Case reference: PAX19.324161  
Lemanaghan Wind Farm

Re: Proposed wind farm of 15 turbines, a permanent 220 kV on-site  
substation and associated infrastructure, etc.

Applicant: Lemanaghan Wind Farm DAC

Figure 1-4 Indicative location of early medieval toghers excavated in Lemanaghan and Derrynagun Bogs in relation to Lemanaghan Monastic Complex and the Proposed Wind Farm infrastructure.

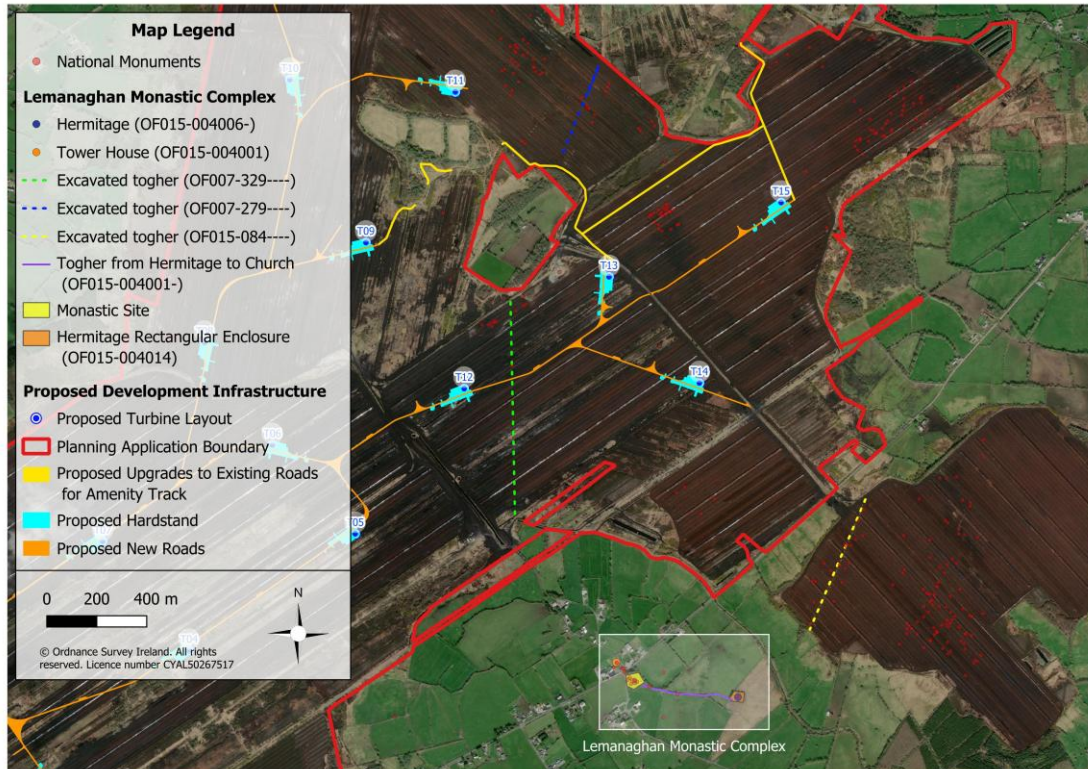
Appendix 13-5 records early medieval Class 1 toghers in and near the proposed project site, including one traced for about **870m** from a dry island within the site toward the Lemanaghan monastic island, and another associated with a wooden crozier. The dates fall around the late 6th/early 7th century, directly relevant to the foundation period of Lemanaghan. See **Appendix 13-5, p. 14.**

The EIAR repeatedly argues that no current formal walking route or visible physical connection remains. See **Chapter 13, pp. 13-75 and 13-132.** But the archaeological setting is not limited to current visitor paths. The loss or obscuring of ancient routeways is itself part of the archaeological sensitivity, not a reason to discount it.
